Please upload as additional consultation from drainage for BN/15/20/PL

BN/15/20/PL at Warren Way, Barnham.

Title
SITE & BLOCK PLANS

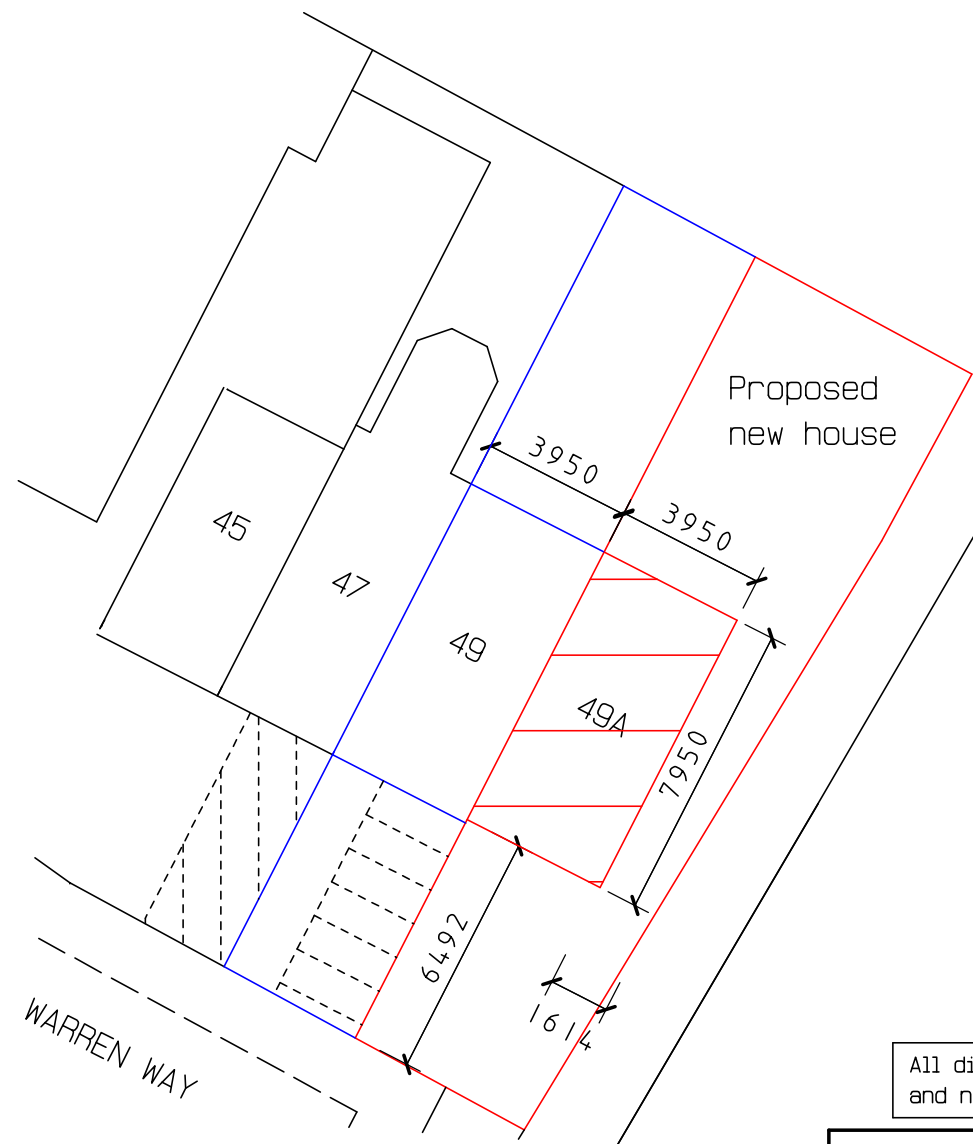
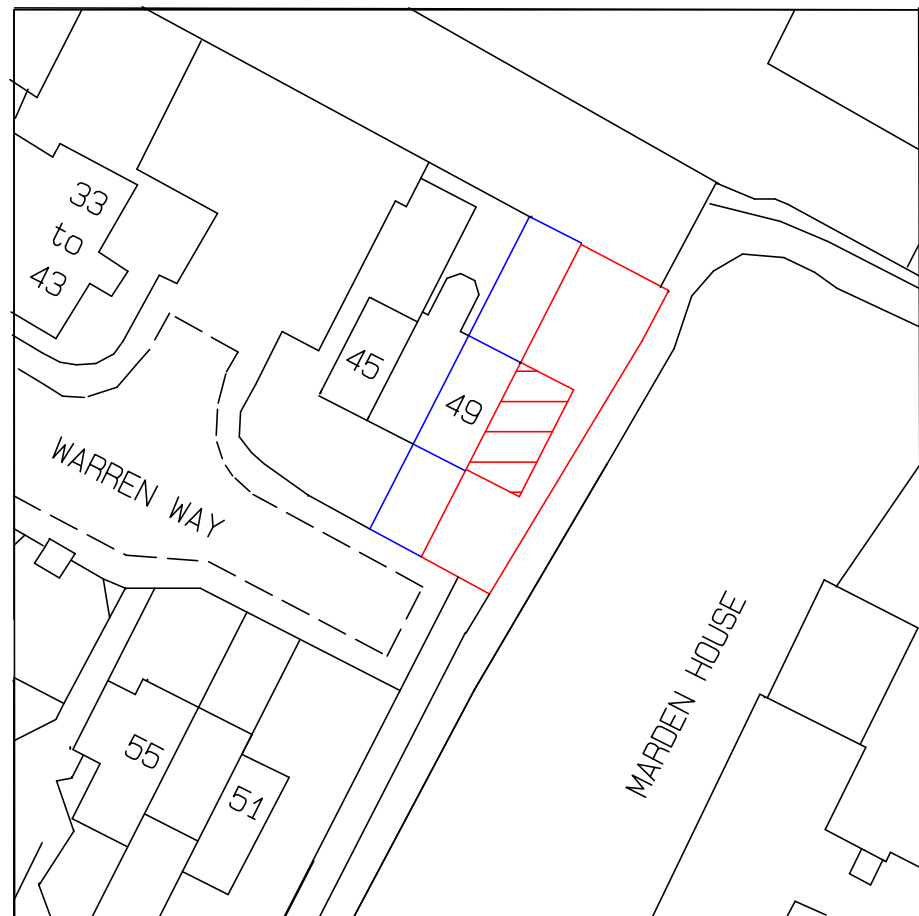
Discharging these conditions will not be straightforward due to the location of the application. To aid the applicant we have considered the problem and suggest that if roof water is attenuated in a sealed system before being discharged to the main river at an agreed rate, and the driveway is an unlined permeable system which can overflow to the main river we may be able to recommend discharge of the conditions. This will involve the applicant getting an Activity Permit from the Environment Agency which will permit the discharge to the main river. In addition, the applicant will need to ensure that the sealed system is designed to account for groundwater at ground level (calcs to show that buoyancy has been counteracted will be necessary).

If the applicant is happy to assume groundwater at ground level then there will be no need for winter groundwater monitoring. If the driveway is assumed to act as attenuation (with whatever infiltration possible allowed by leaving it unlined) then no infiltration testing will be required.
